Application: New Dwelling 77 Latham Lane Gomersal Cleckheaton BD19 4BU  
Applicant: Mr S Akbar  
Project: 4340  
Date: May 2019

This supporting statement has been prepared by Heppenstall Architects on behalf of the applicant, to accompany a condition variation application submitted following consultation with Kirklees planning on the previously approved 2018/62/92850 application.

Number 4340-04-01  
 Checked Scale @ A1 1:100  
 Date 02/2019

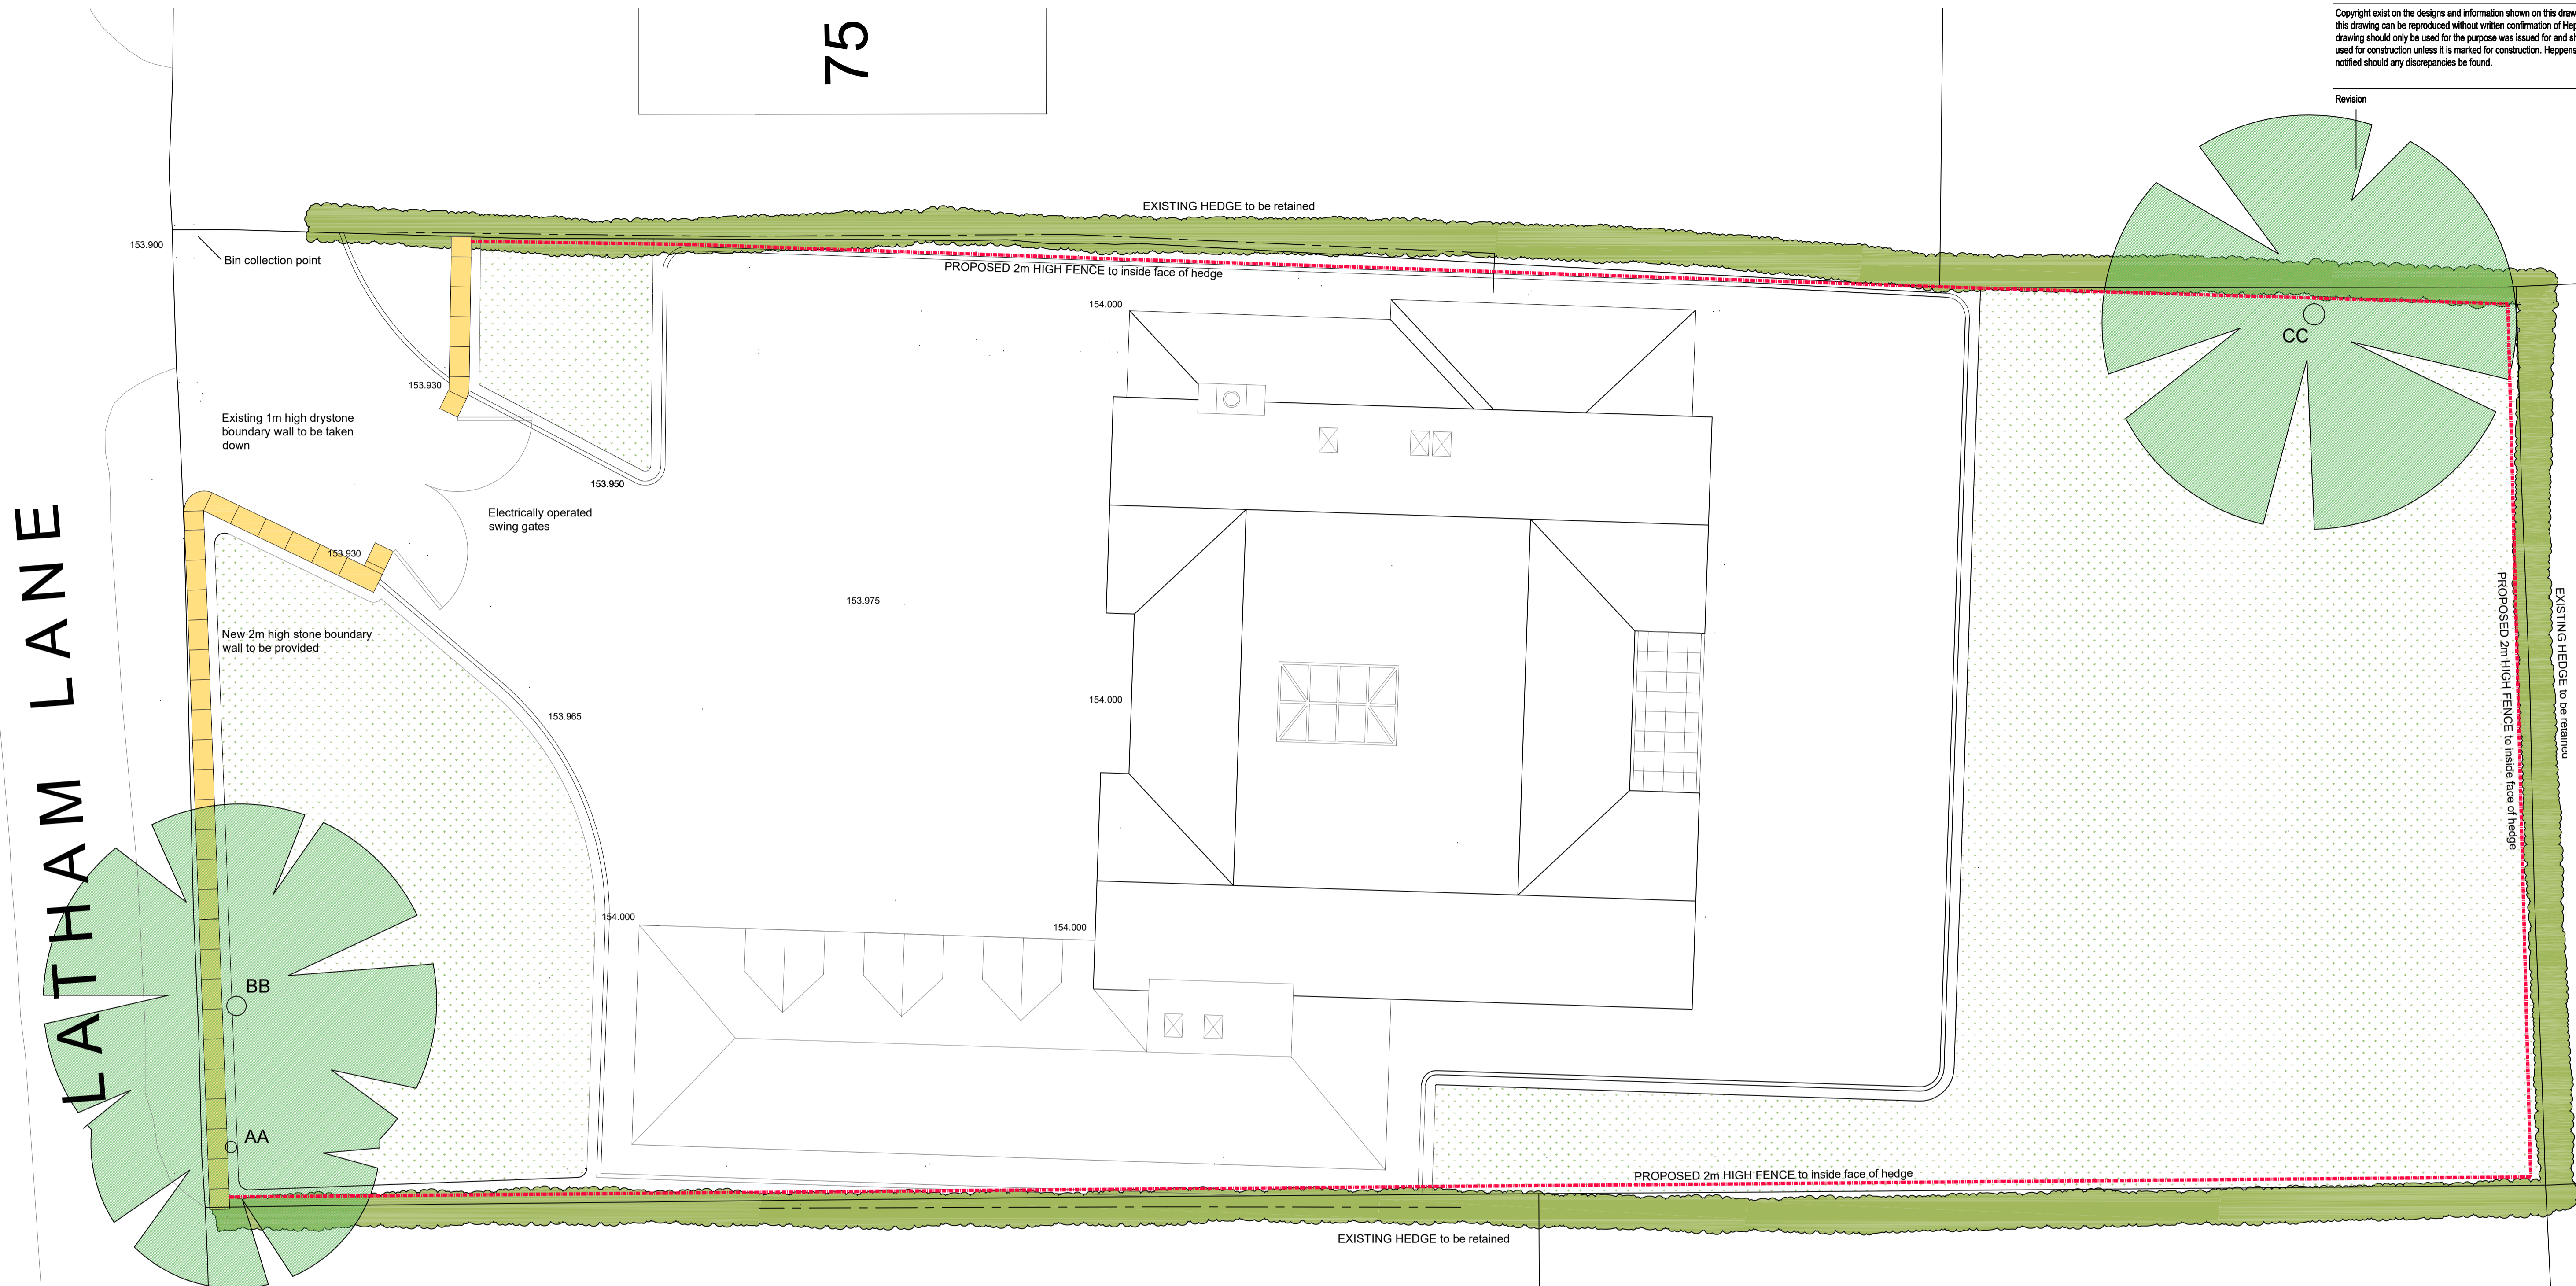
Condition 4 & 6 attached to the approval relates to a previous approval landscaping drawing which does not completely relate to the 2018/92850 approval.

This application seeks to amend the landscaping scheme relating to the approval for a single dwelling and shows the 77 Latham Lane east boundary wall in the current position and rebuilt to 2m in height.

Client A. Saeed.		
Project Proposed House, 77 Latham Lane, Gomersal.		
Drawing Planning Site Plan		
Number <b>4340-04-04a</b>	Checked Scale @ A1 1:100	Date 02/2019

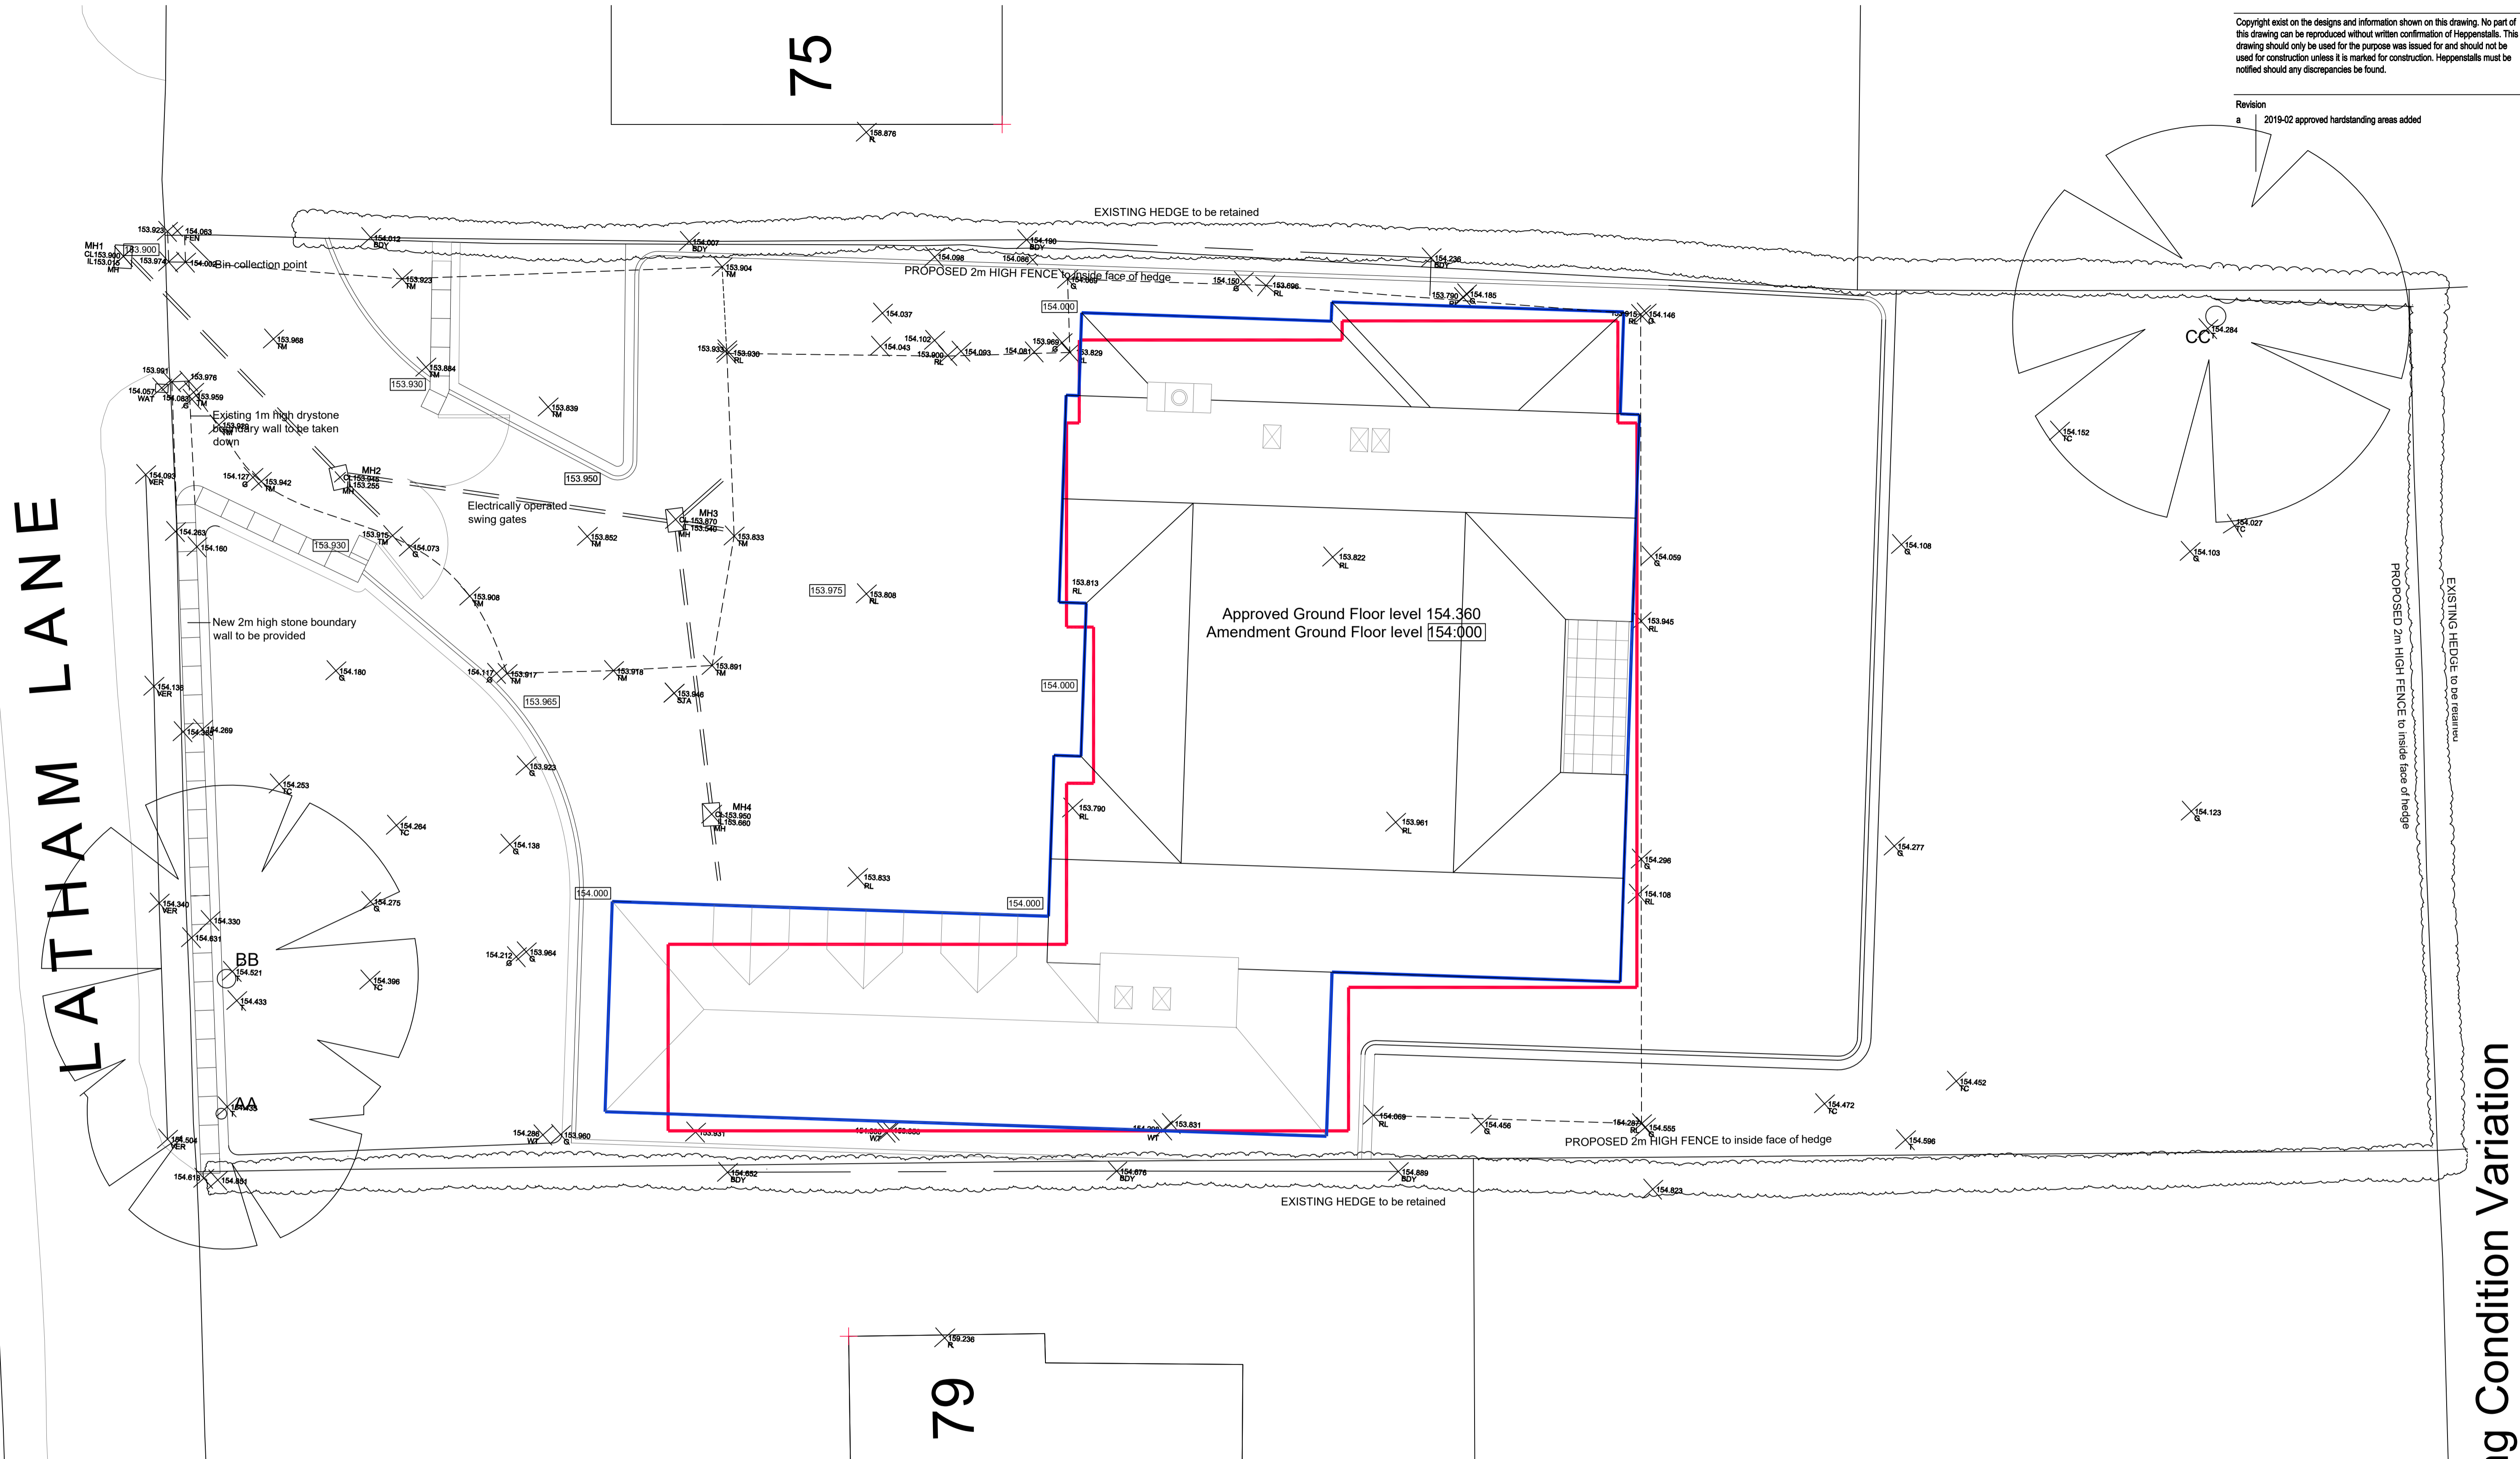
The position of the building on site has slightly changes as a result of the slight increase in the garage size. The submitted drawing 4340-04-04a shows a comparison between the previously approved building footprint in red and the proposed amended building footprint in blue.

The aim in slightly repositioning the 0.65m wider footprint has been to maintain the minimum clear widths to both the North and South boundaries shared with numbers 79 and 75 respectively.

This amended position reduces the clear width to the south number 75 boundary hedge line from 1.6m to 1.3m and the clear width hedge line to the north number 79 boundary from 65cm to 51cm.
